**Tallawong Station Precinct South
Stage 2 (SSD-10425) and Modification Application (SSD-9063-MOD-1)**

Attachment A

Project No. **18095** Drawn by **TURNER**

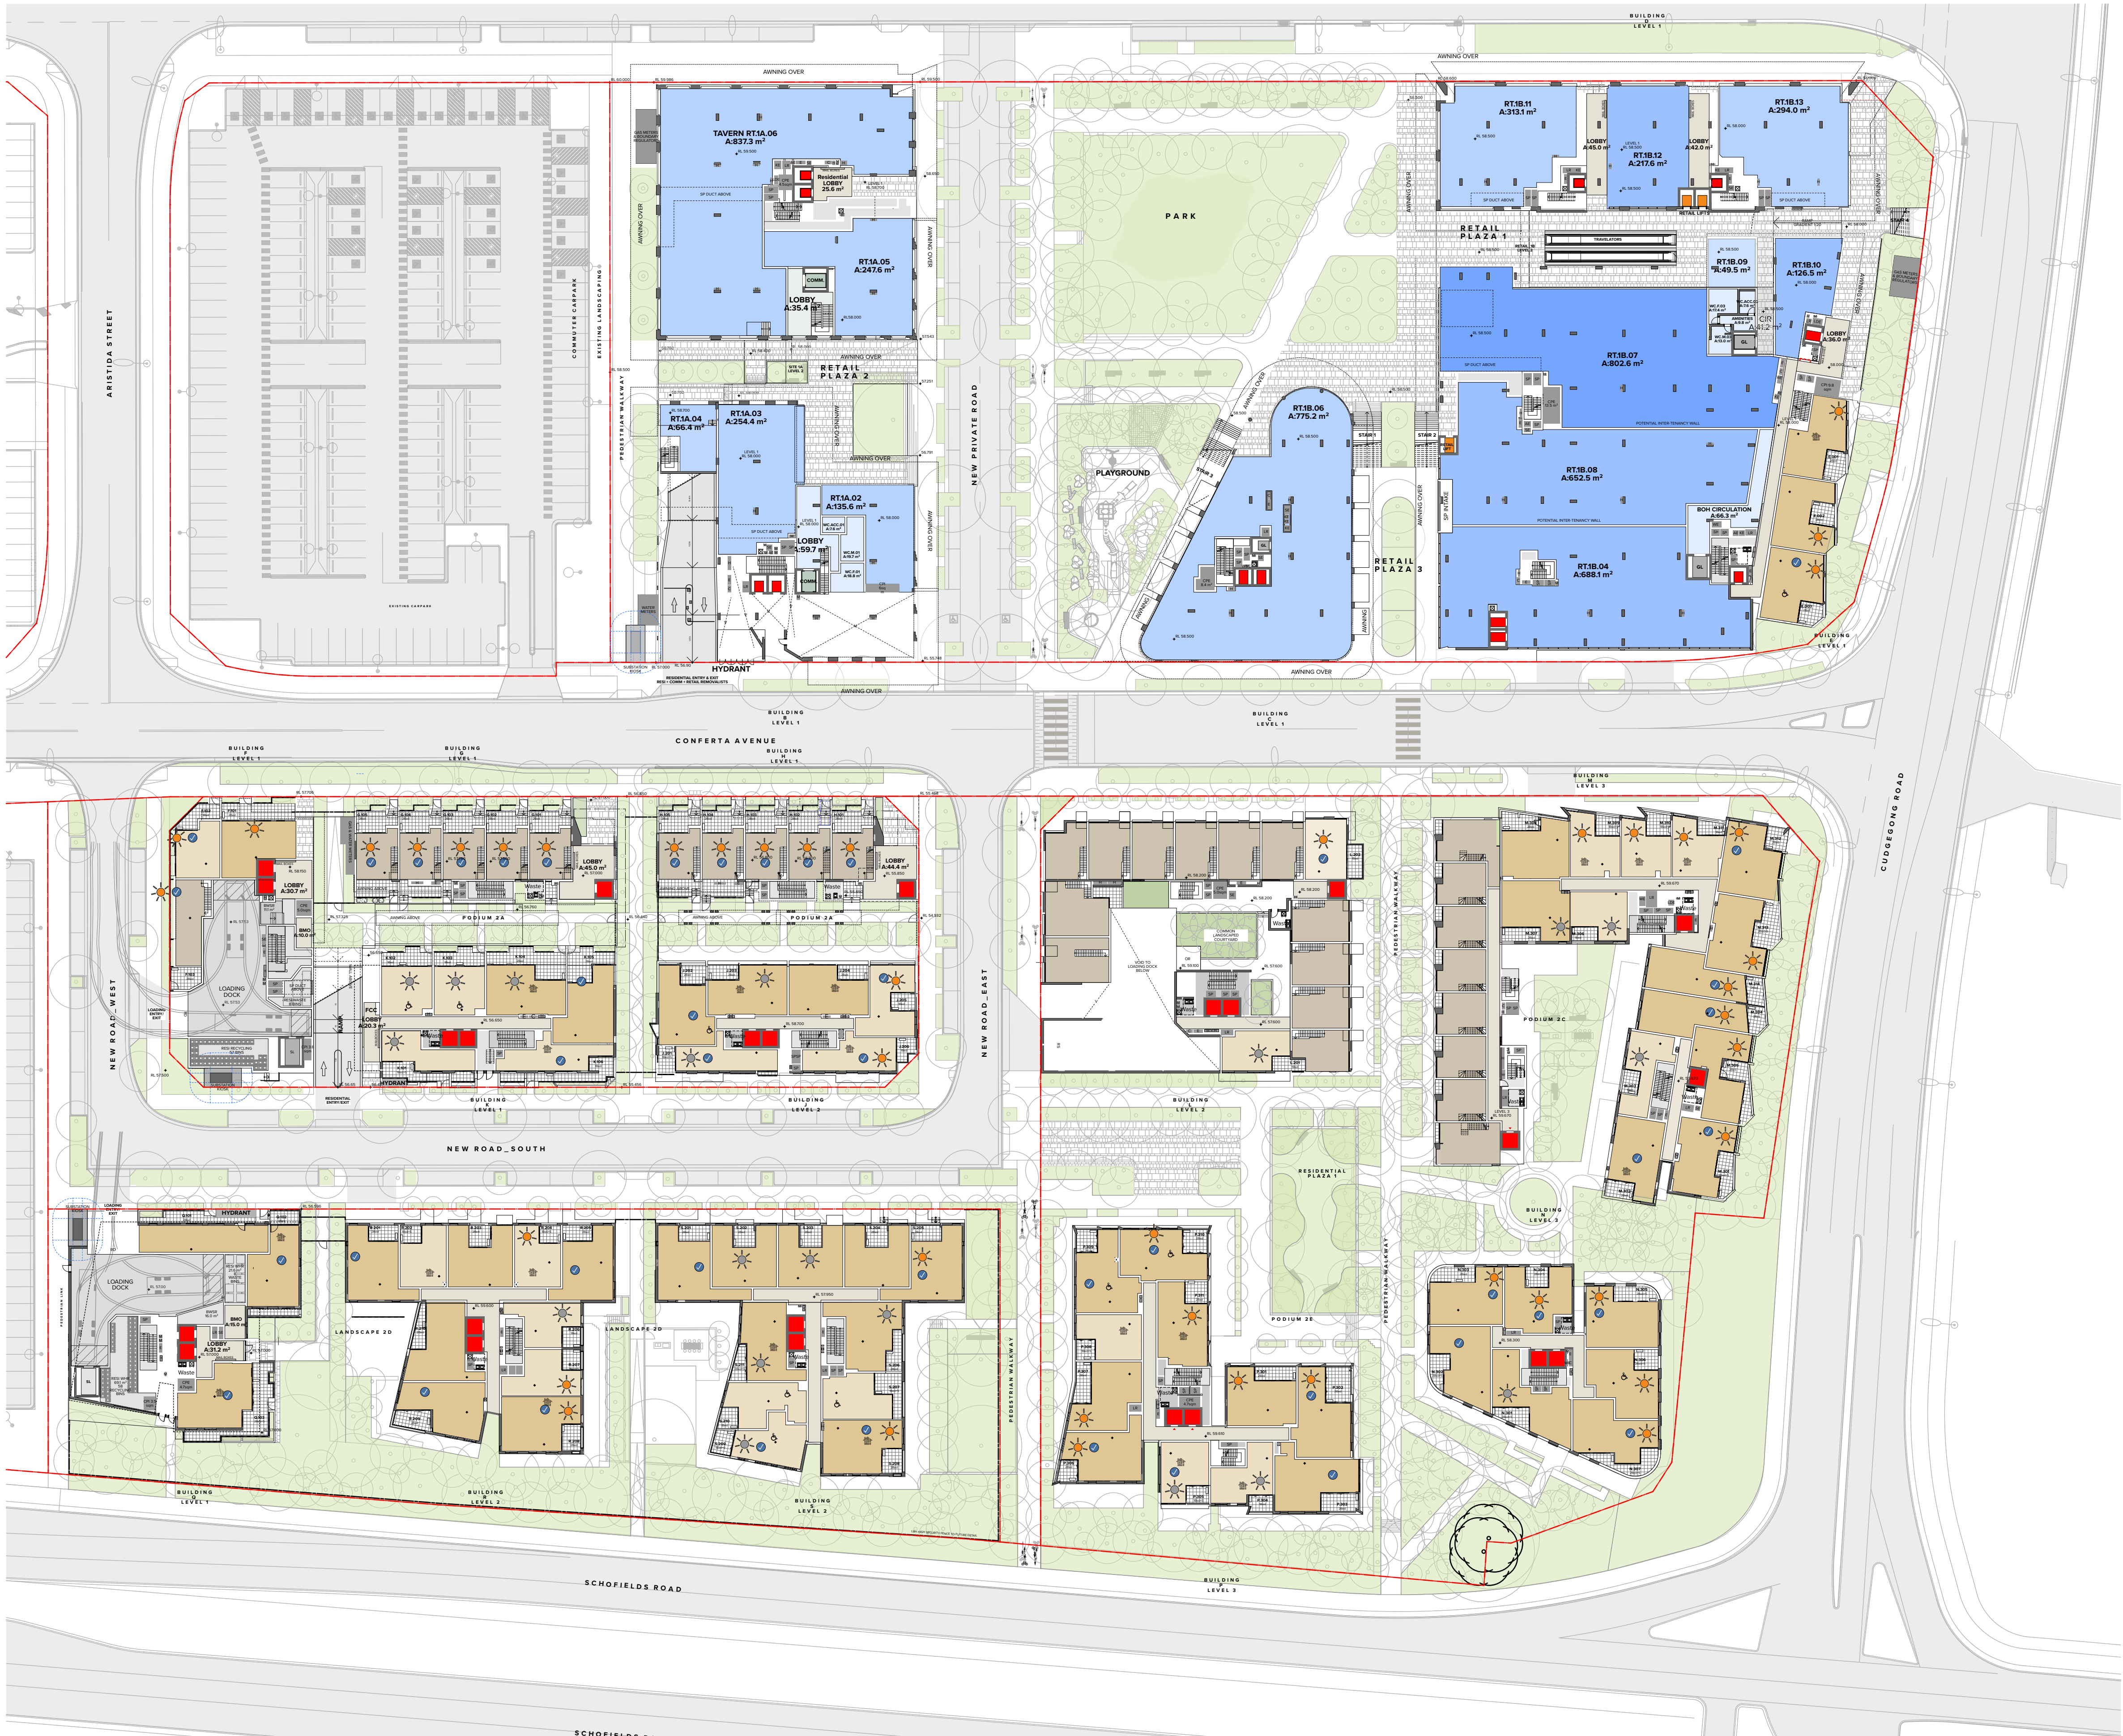
- i. Provide further information and analysis to demonstrate the proposal's compliance with the Apartment Design Guide (ADG), particularly how solar access and ventilation would be achieved for each of the proposed buildings. This must include (but not limited to):

- a. solar access diagrams to illustrate how solar access would be achieved for the proposed apartments
 - b. clarify how cross-ventilation and natural ventilation are achieved for apartments affected by rail and road noise.
